Transgrid Reference: 2021-226

DPE Reference: State Significant Development SSD-17552047

Location: The Edge Estate – 155-251 Aldington Road Kemps Creek (Lot 33 DP 258949 and Lots 25-28 DP 255560) as described by NSW Dept of Planning and Environment

Proposal: Development of a warehouse and logistics hub, including construction of eight warehouses with a total of 153,343 m2 of gross floor area, one collector road connecting to Aldington Road, two estate roads, a 14-lot Torrens Title subdivision, site-wide bulk earthworks and remediation works.

TRANSGRID PAD
ARRANGEMENT

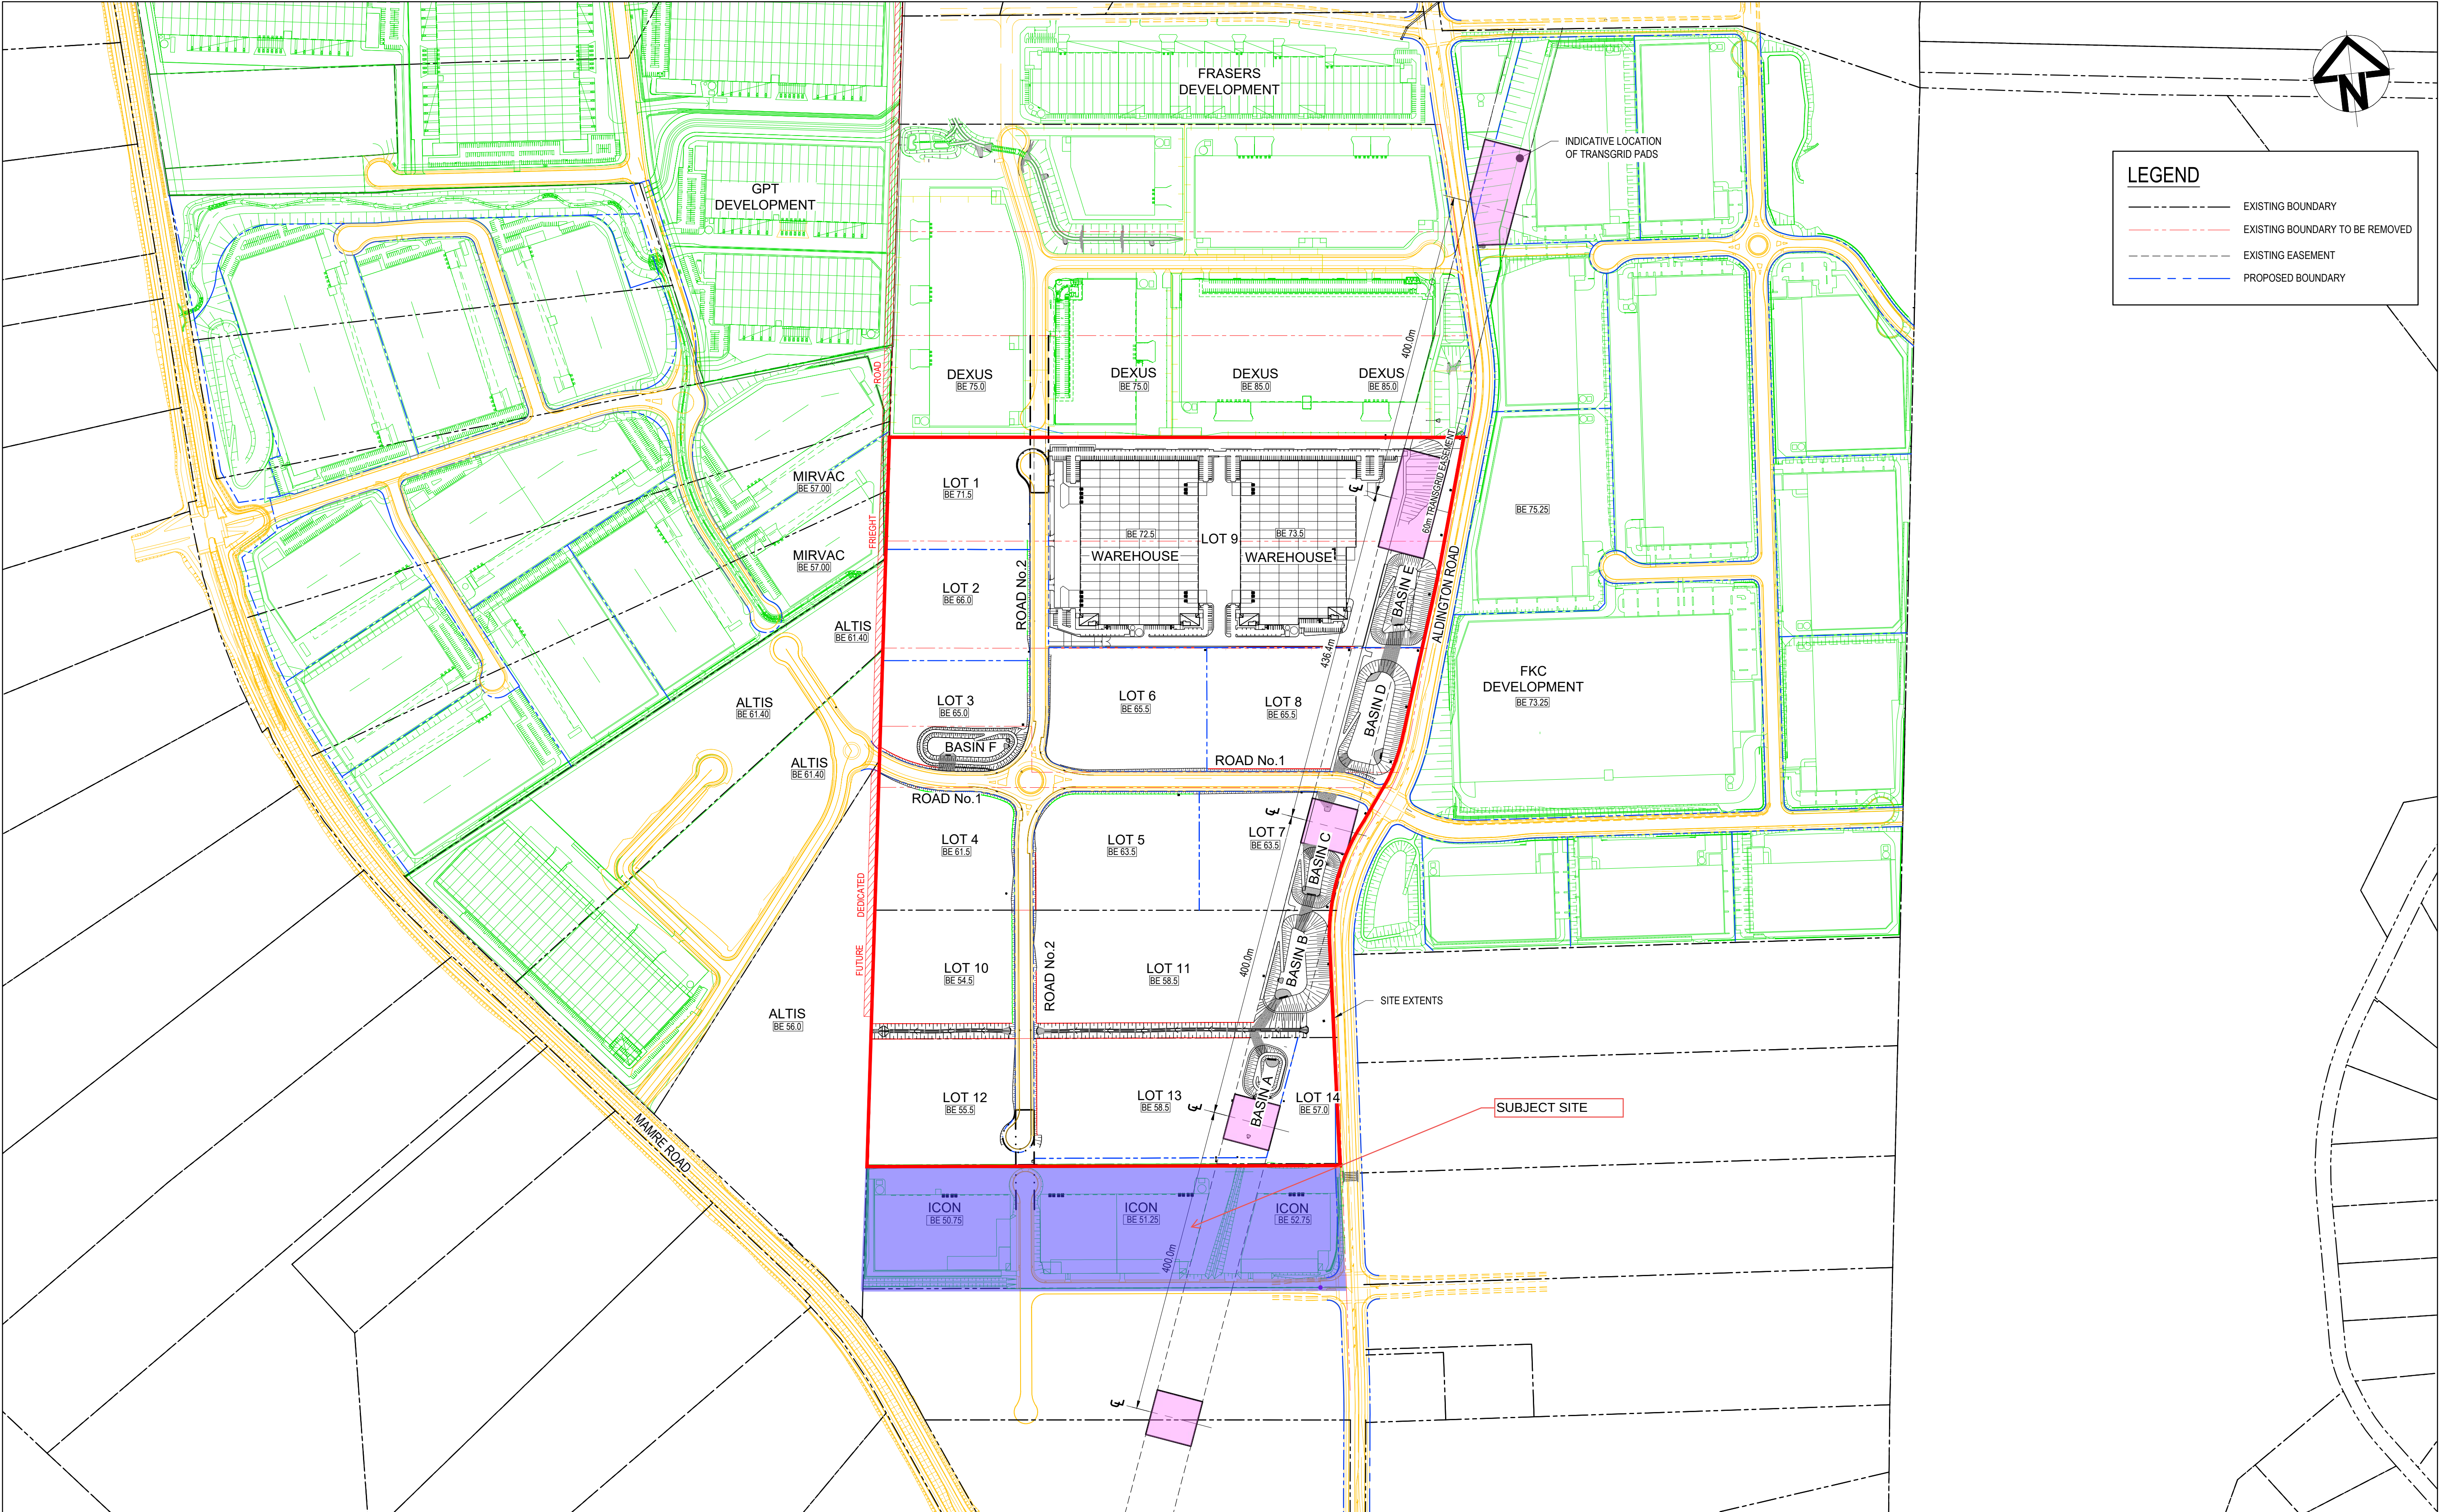
- e. There are three indicative locations for Transgrid Tower Pads within the easement.
- f. A Trunk Stormwater Drainage channel is proposed on the south side of this development within the Transgrid easement.

- c. Transmission lines in Transgrid's unencumbered easement may be installed in the early 2030s. The Proponent must provide the 60x60m square clearances to structures indicated on Civil Works Package drawings.

- d. The Proponent acknowledges that the locations shaded in pink and described as "Indicative Location of Transgrid Easement Pads" on Civil Works Package Drawing No. 20-776-C1006 AI Issue I dated 19-09-23 will be preserved for the installation of Transgrid structures which will support future high voltage TLs to be installed in the easement.

- j. Vehicle parking is not permitted:
 - i. in the centreline exclusion zone (17m each side from the centreline)
 - ii. within the 60m x 60m (or larger) pad locations for structures indicated in the drawing referenced in CI 4 (b) above.

- ii. Batter slopes should remain outside of the exclusion zones around future structure pad location.
- f. The three indicative locations for Transgrid Tower Pads within the easement appear to have batter slopes directed towards them:

- i. The subsoil stability and surface drainage is not to be adversely affected in the vicinity of possible future structure pad locations.
 - ii. Water flow will need to be directed away from future structure locations to avoid any water retention issue, which could have an adverse impact on the structures (particularly tower legs)
